170 Slater Street

Urban Design Review Panel Recommendation Responses 170 Slater Street

**RE: Urban Design Review Panel Recommendation Responses
PC2023-0379
170 Slater Street – Site Plan Control**

SOUTH ELEVATION - NORTH TOWER
1:150

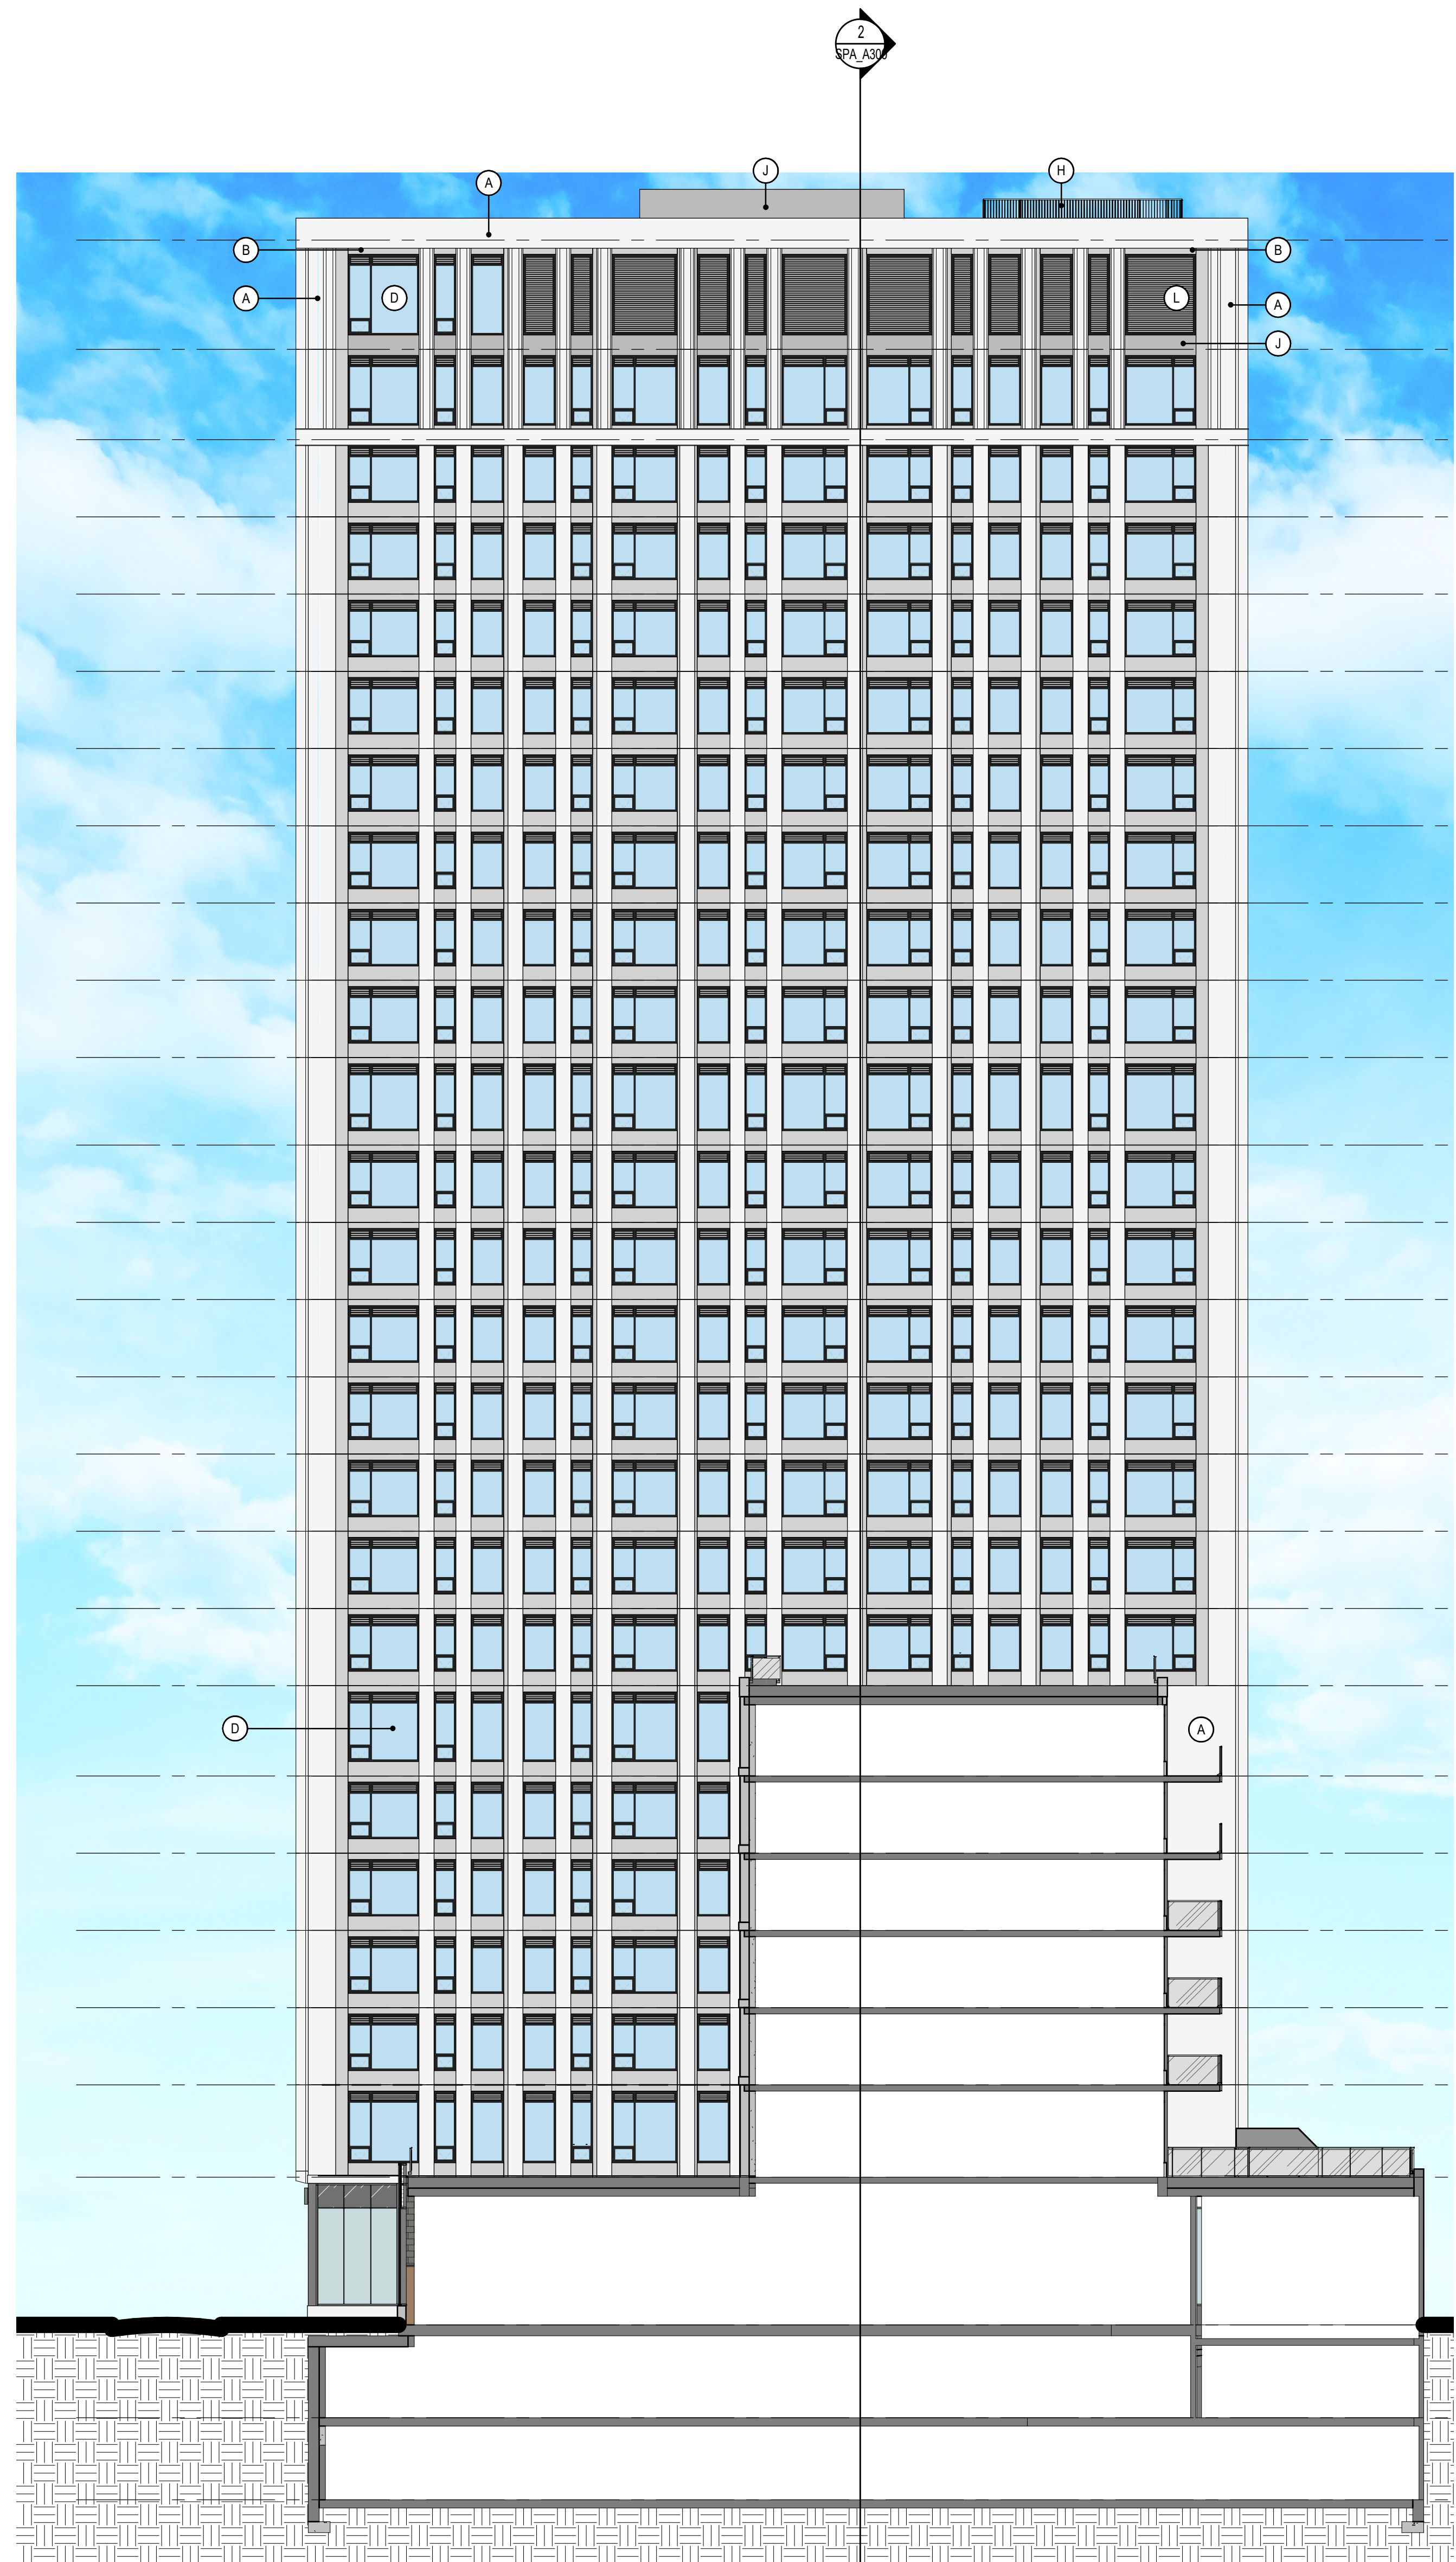
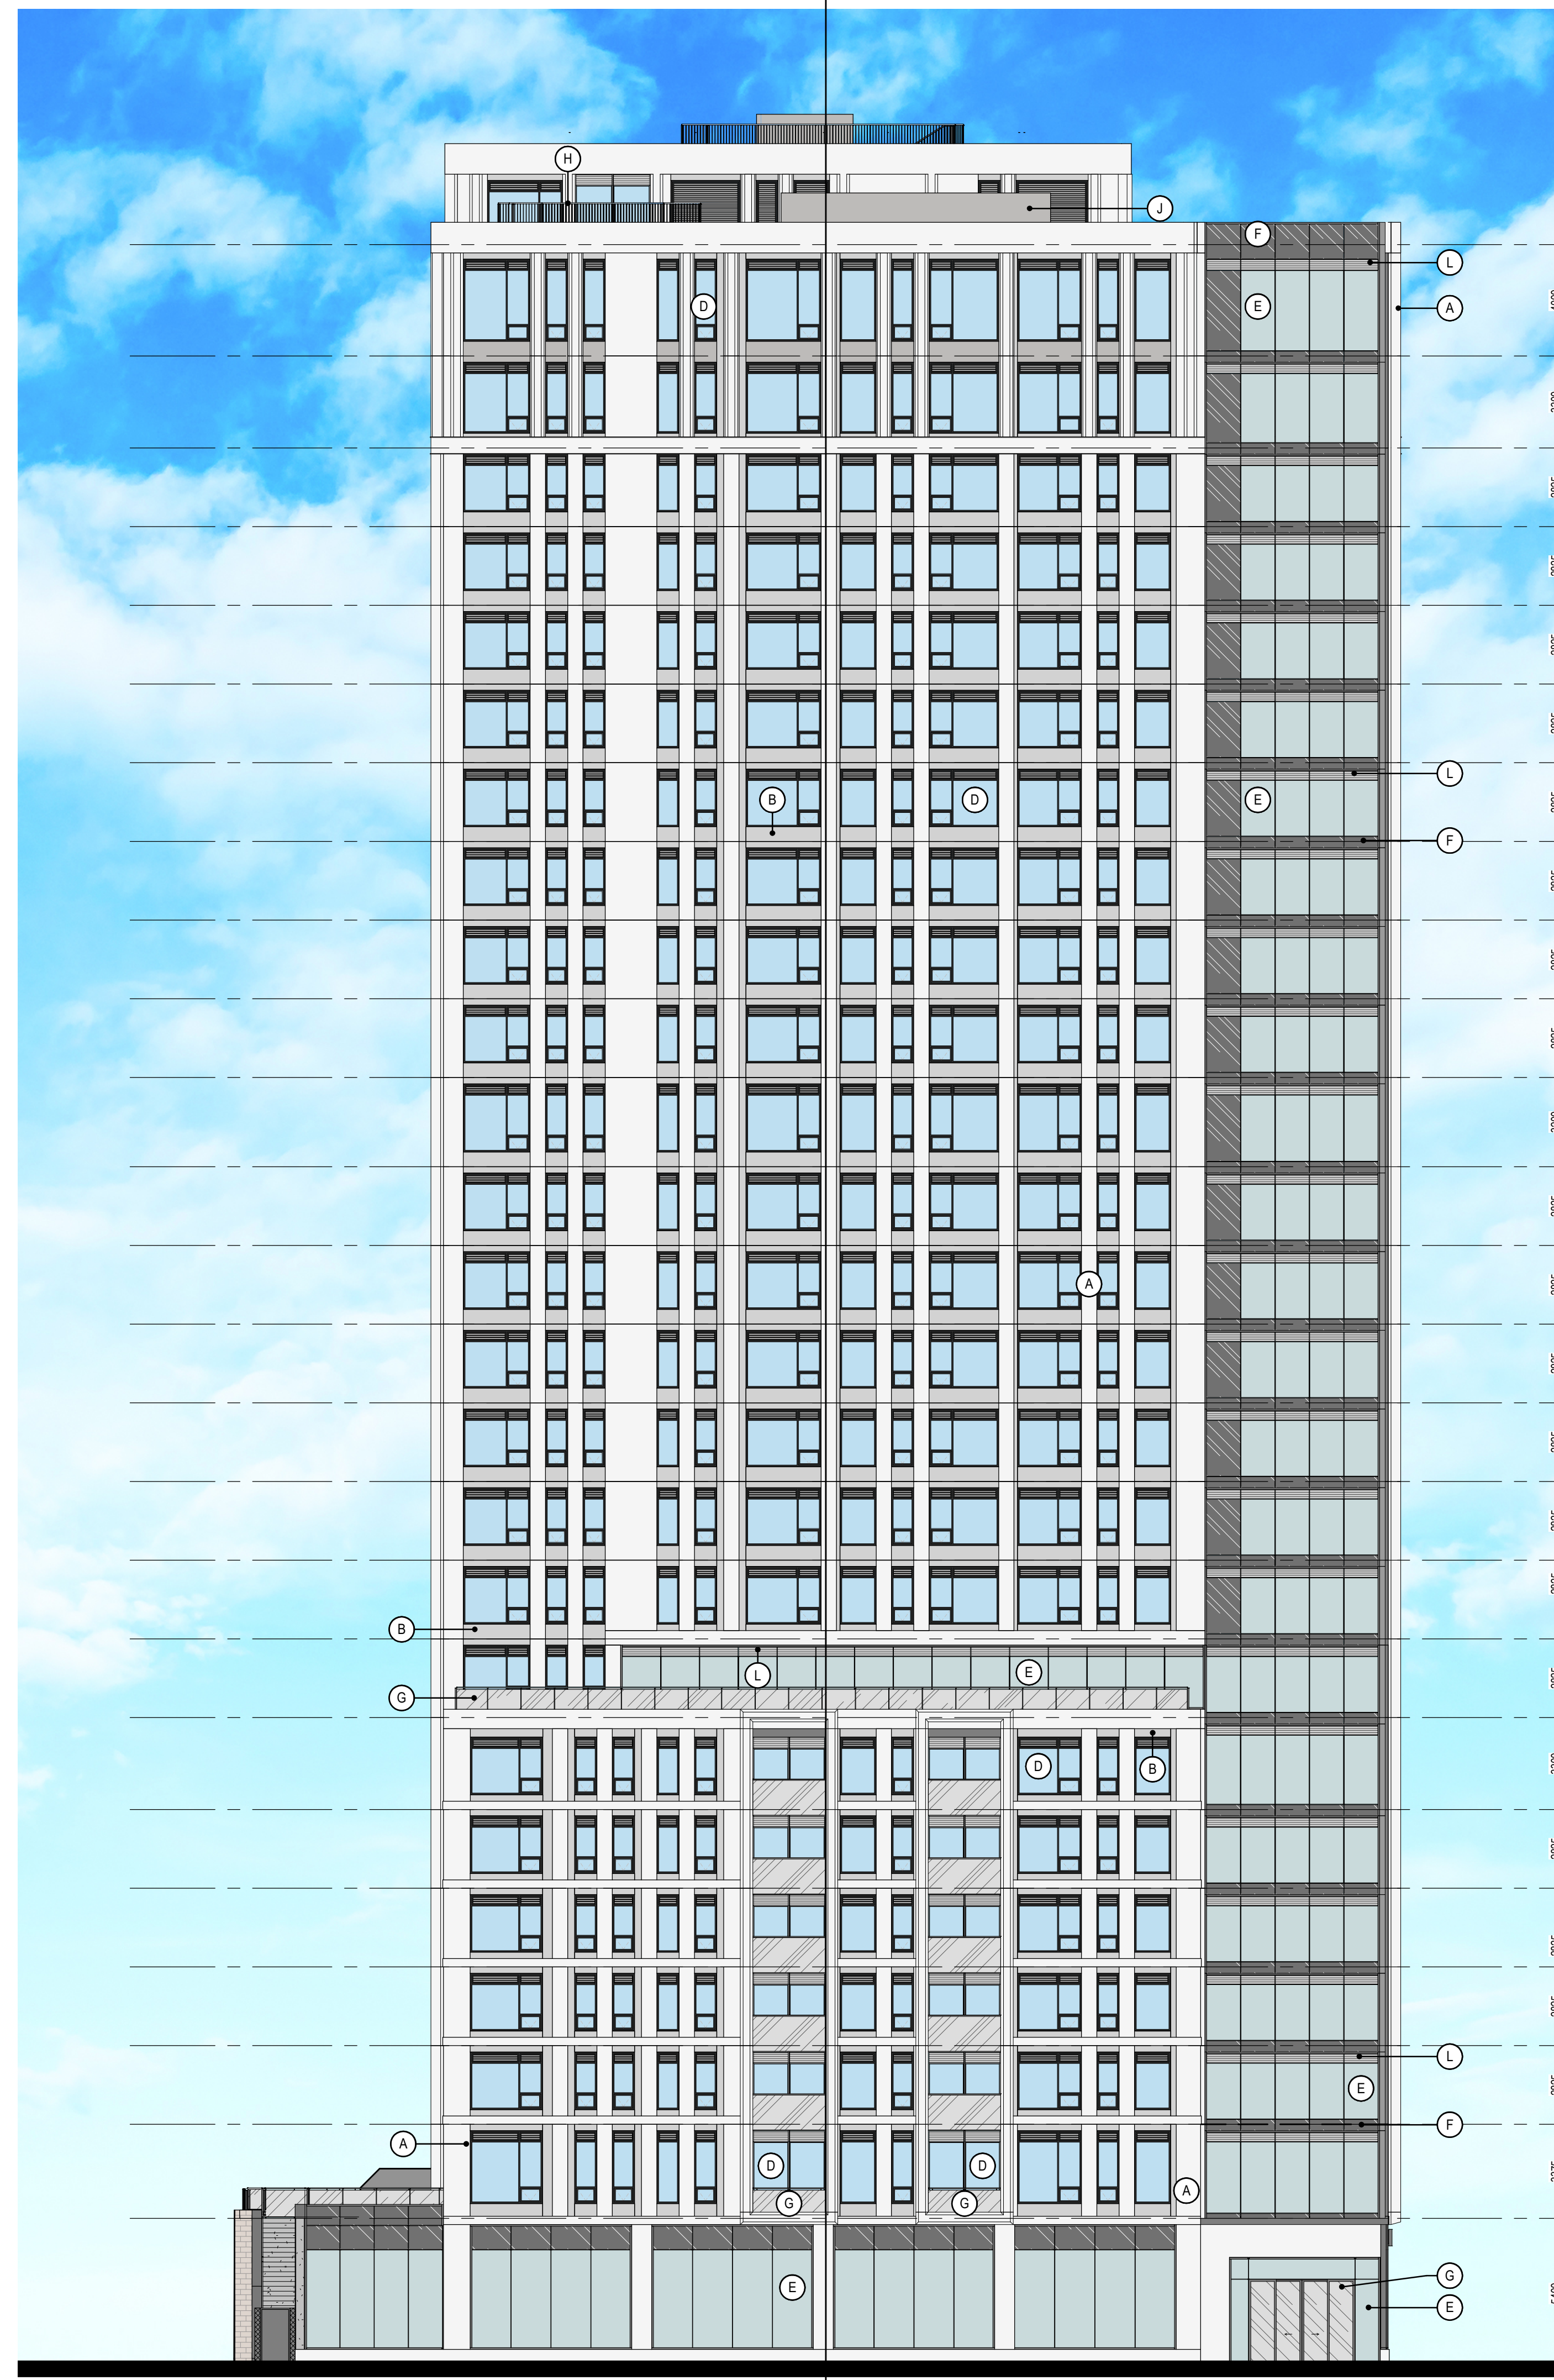
30 The Panel has concerns with the dark colours of the materials as viewed in the renderings and perspectives.

/ Consider pursuing lighter coloured materials as shown in many of the inspirational images on page 8.

The material has been updated to a lighter colour.
